Gate Burton Energy Park

EN010131

Applicant Responses to Interested Party Submissions at Deadline 2
Document Reference: EN010131/APP/8.15
September 2023

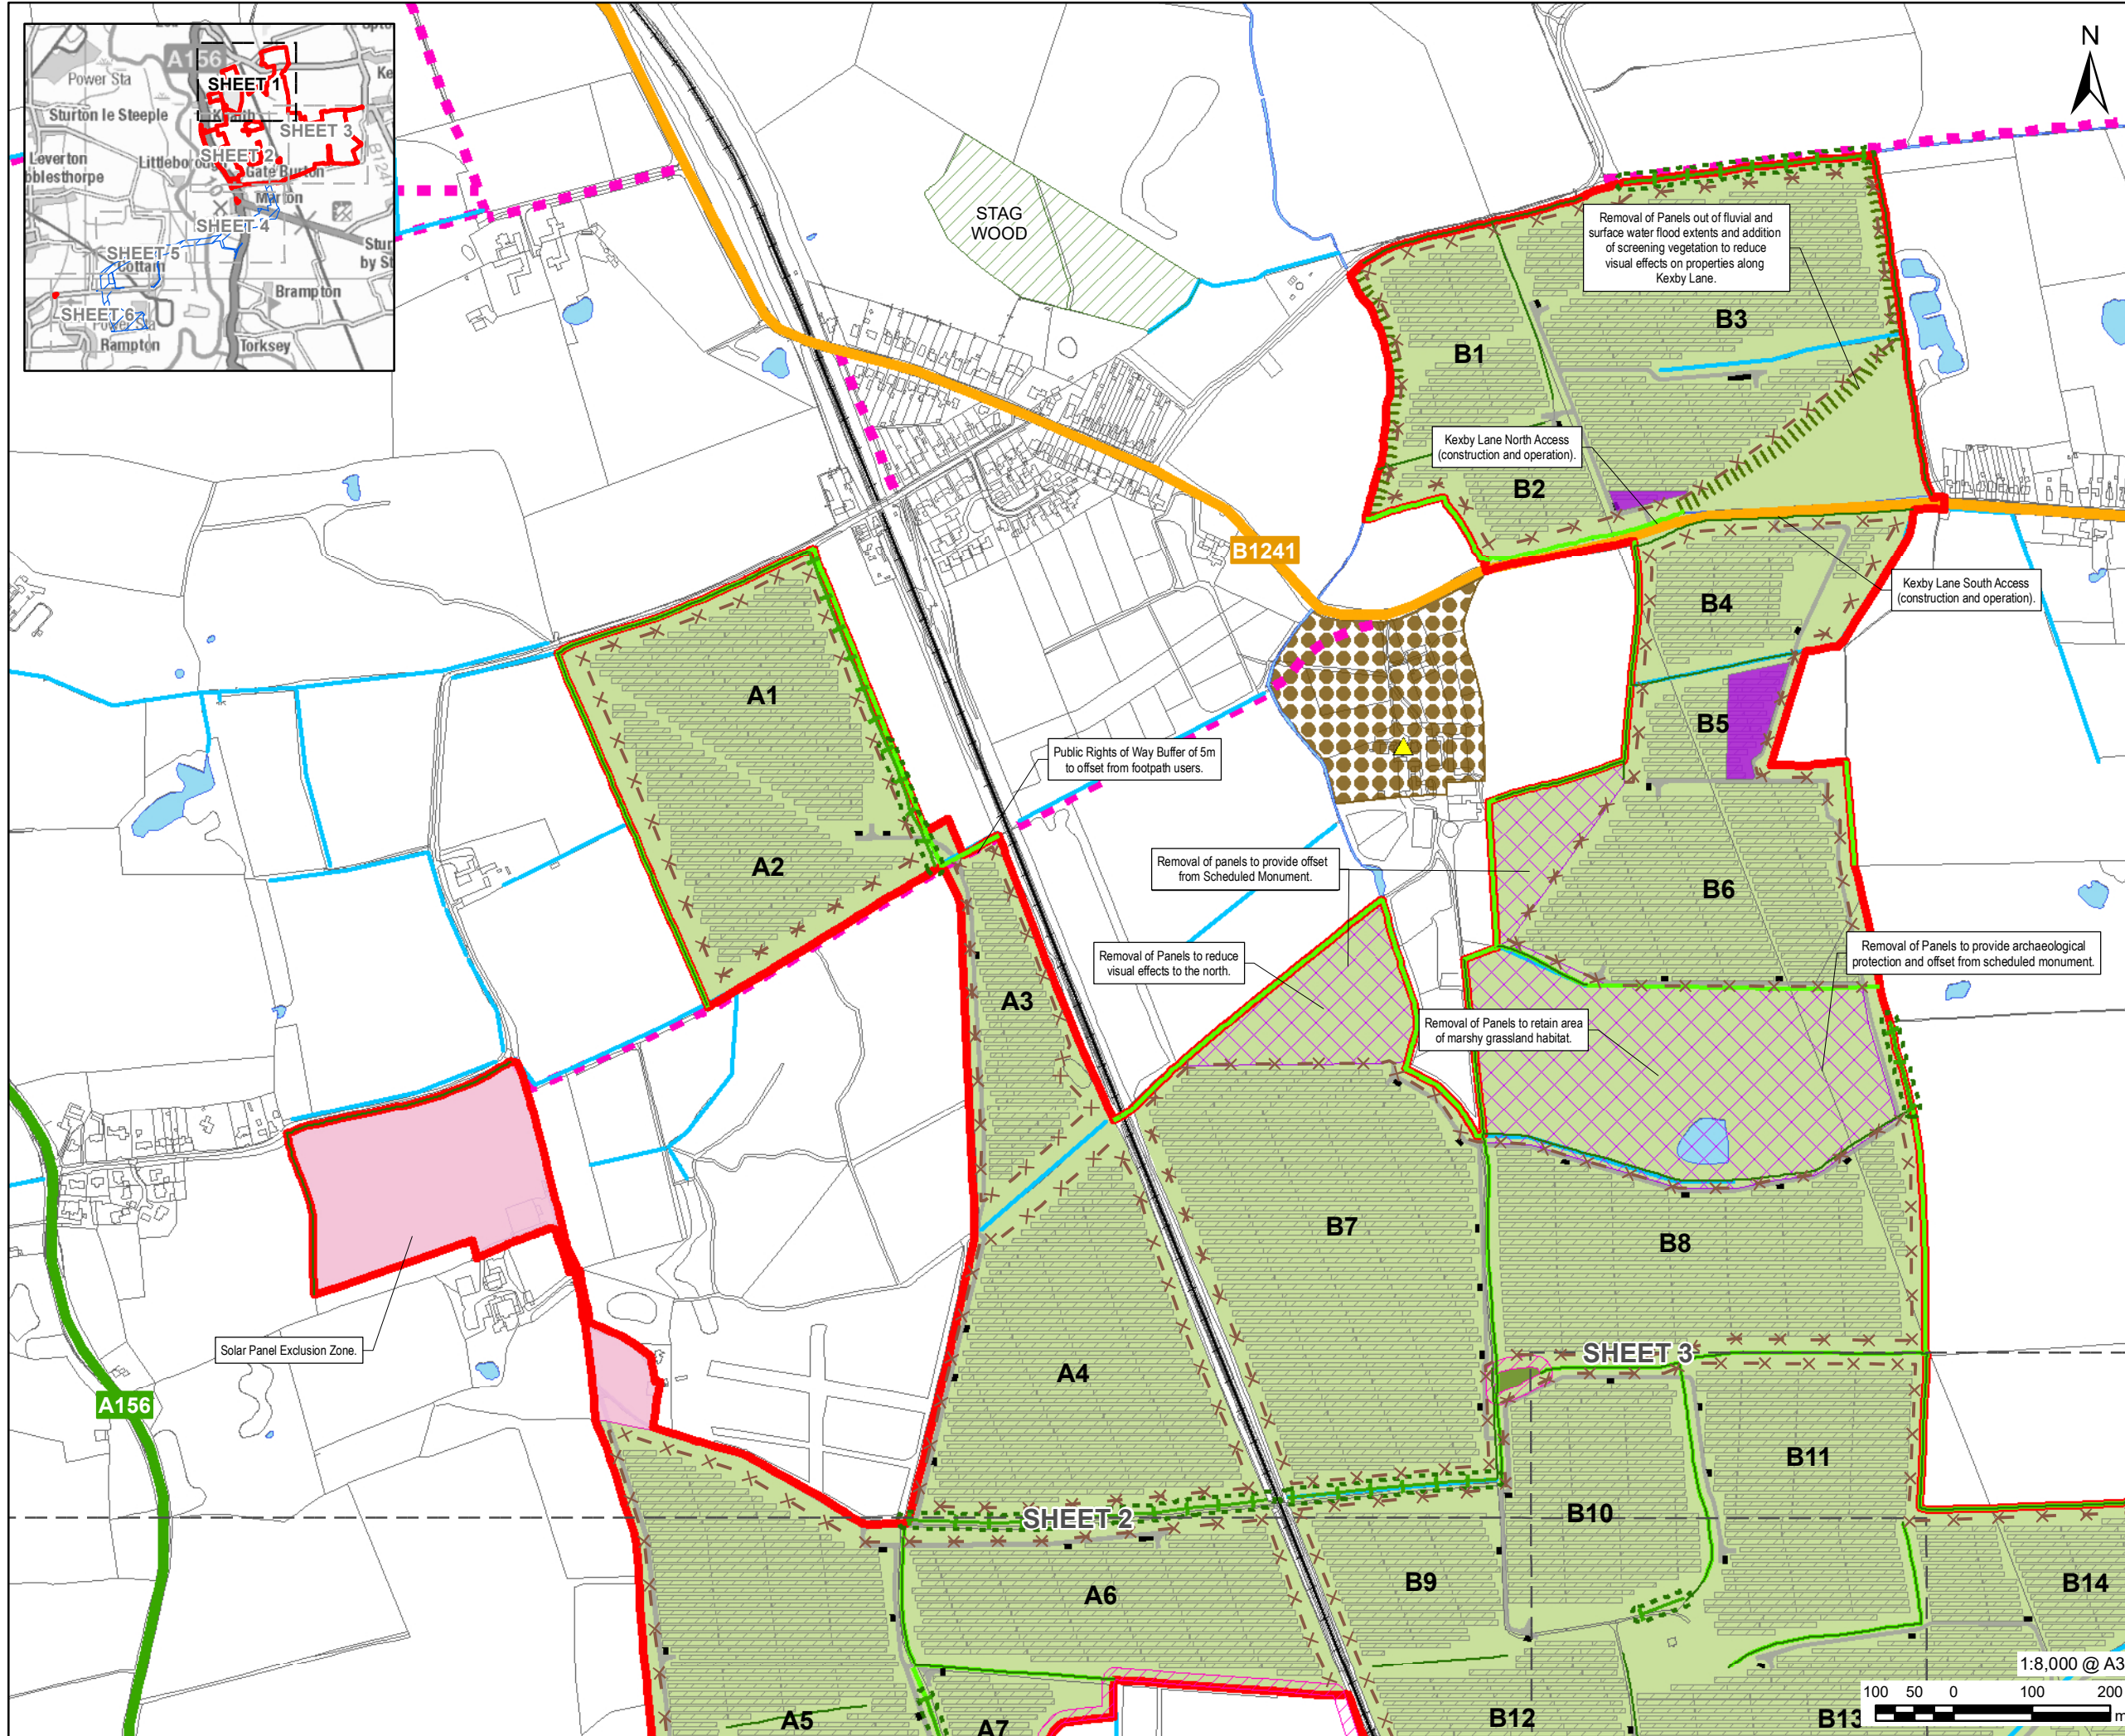
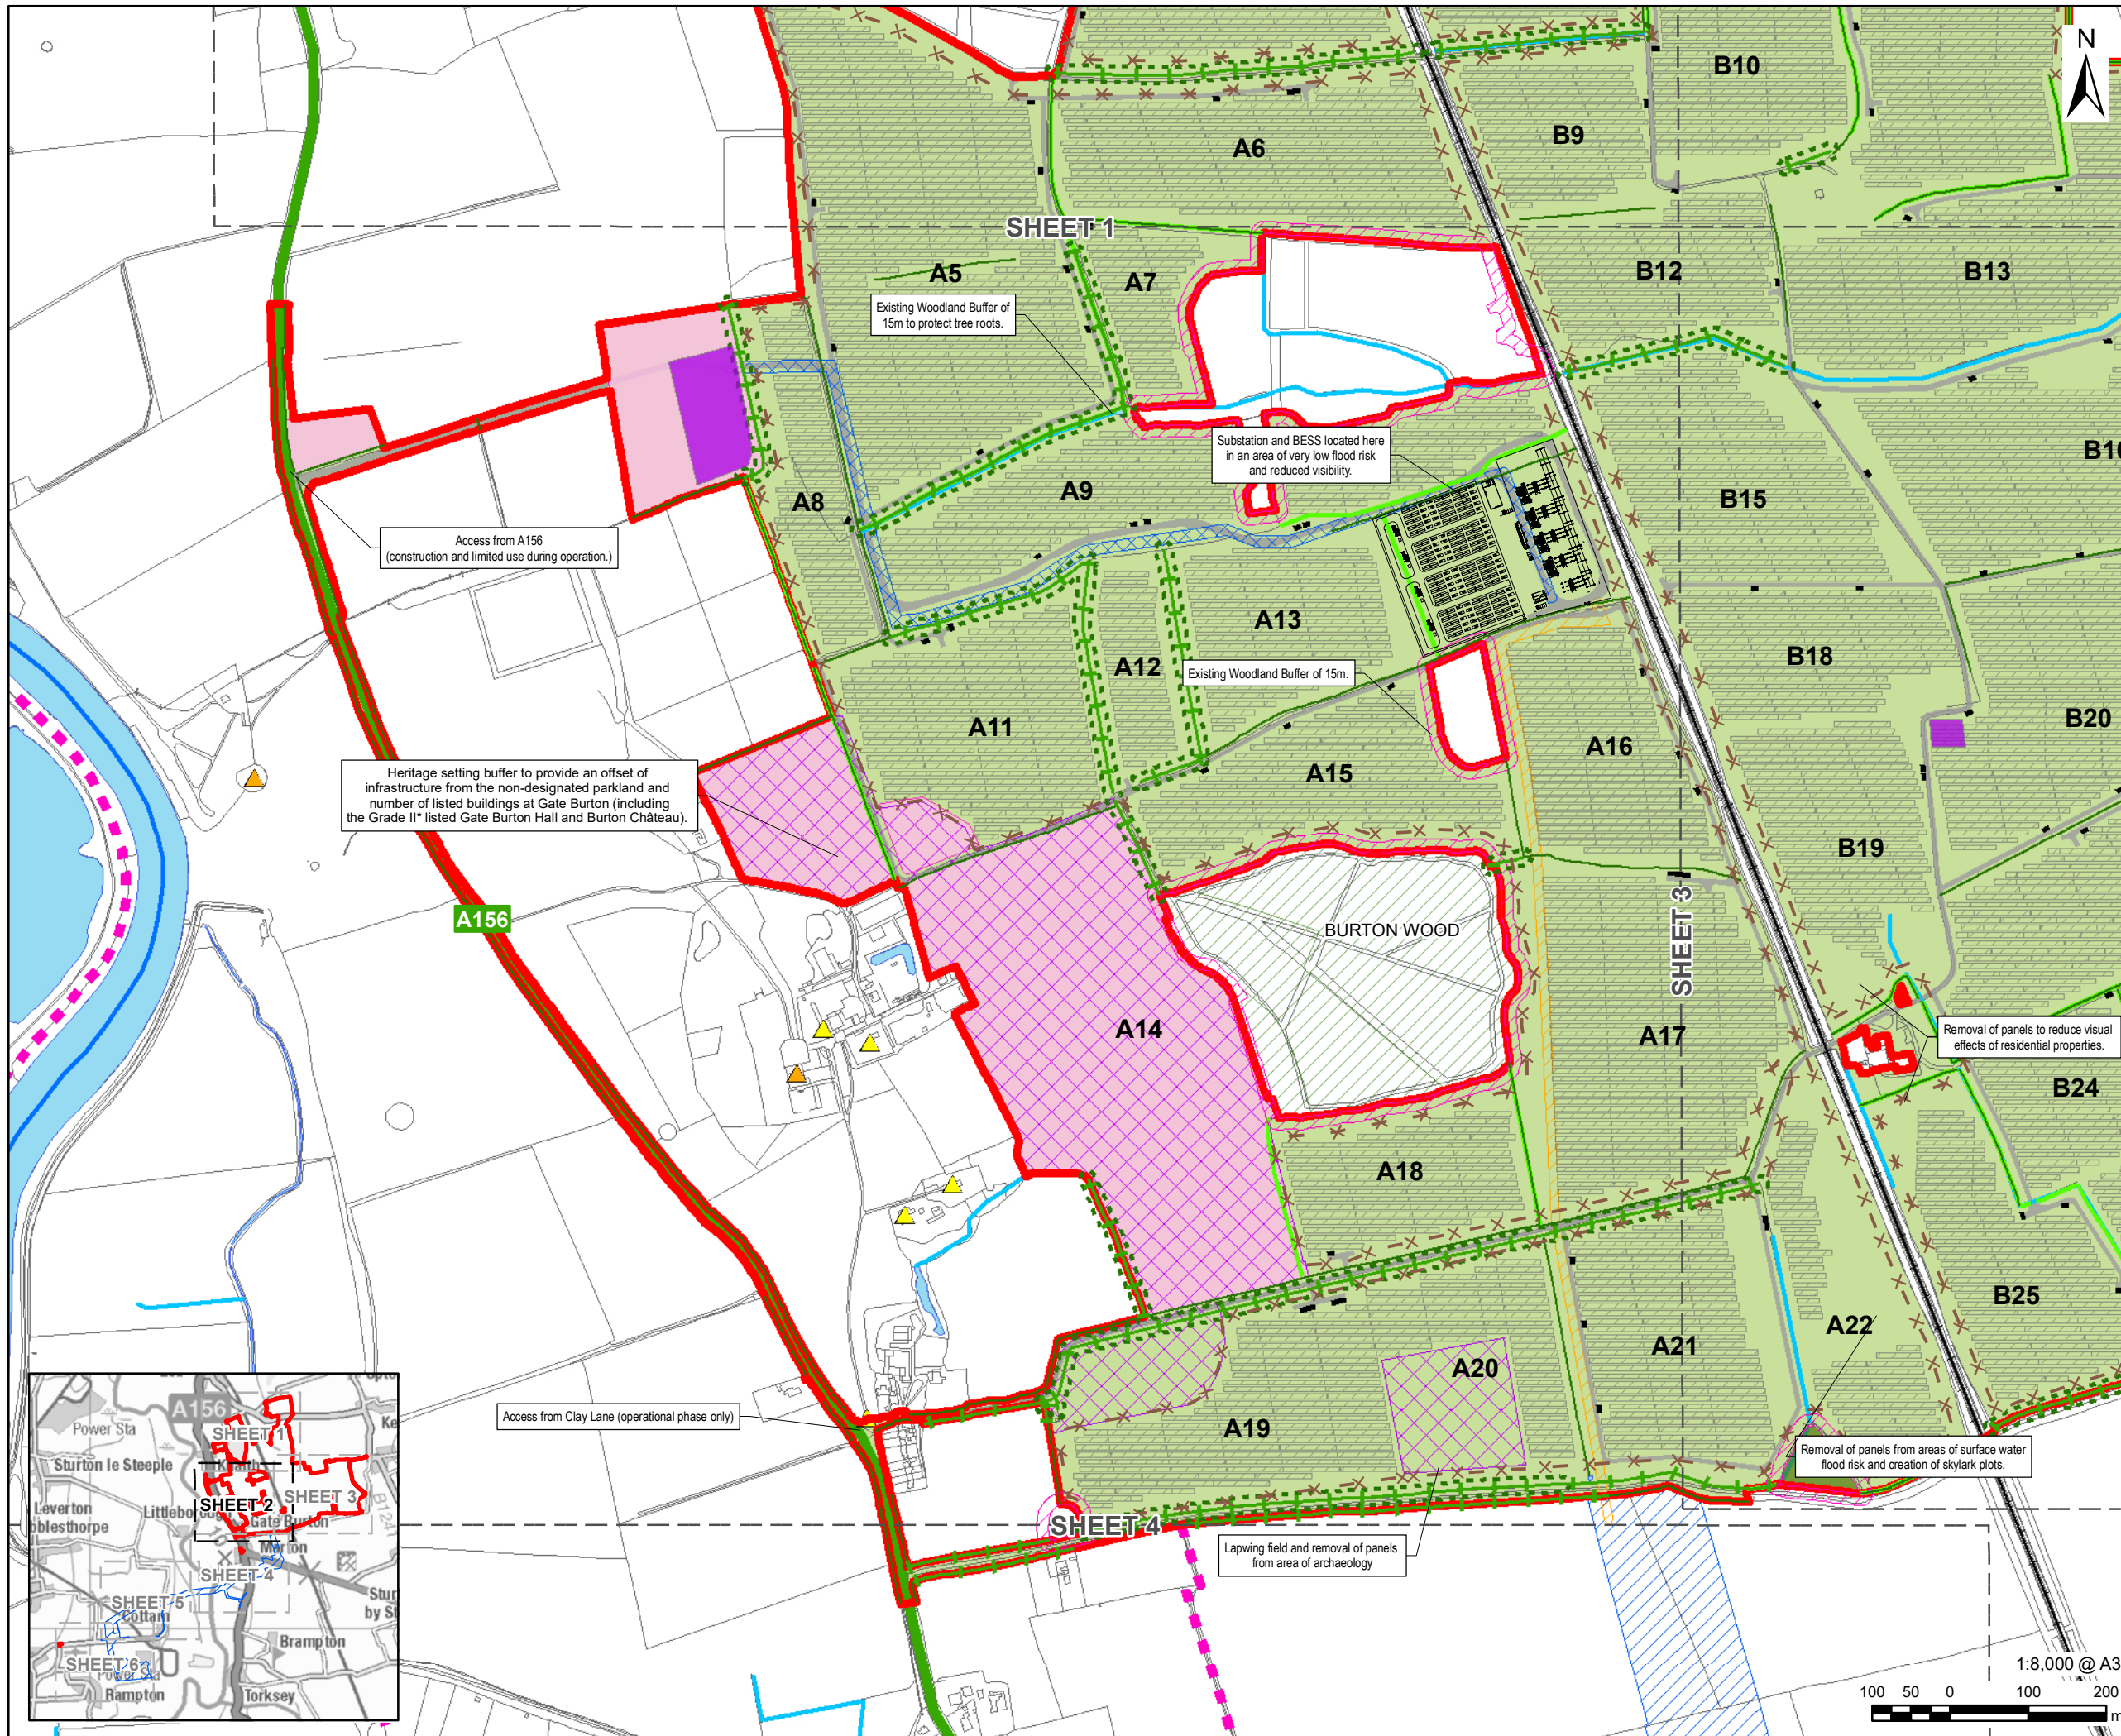
Response Reference	Question Number	Summary	Applicant response
REP2-053 (NCC)	1.7.6	<p>Re ExA question on Outline Design Principles (ODP) Heritage Setting Buffer (ES Volume 2: Figure 2- 4) – “Given the direct reference to Figure 2-4 [APP033] to identify the location of the Heritage Setting Buffer how is this to be secured as this is not identified as a certified document? If not, why not?”:</p> <p>NCC can confirm that the ‘heritage buffer zone’ is in Lincolnshire and does not affect Nottinghamshire/Bassetlaw. However, NCC do consider if the Burton Wood redline excluded area could be extended to take in A14 (the Heritage Buffer Zone).</p>	<p>The Heritage Setting Buffer located between Gate Burton Hall and Burton Wood has been agreed in consultation with Historic England and therefore cannot be removed.</p>
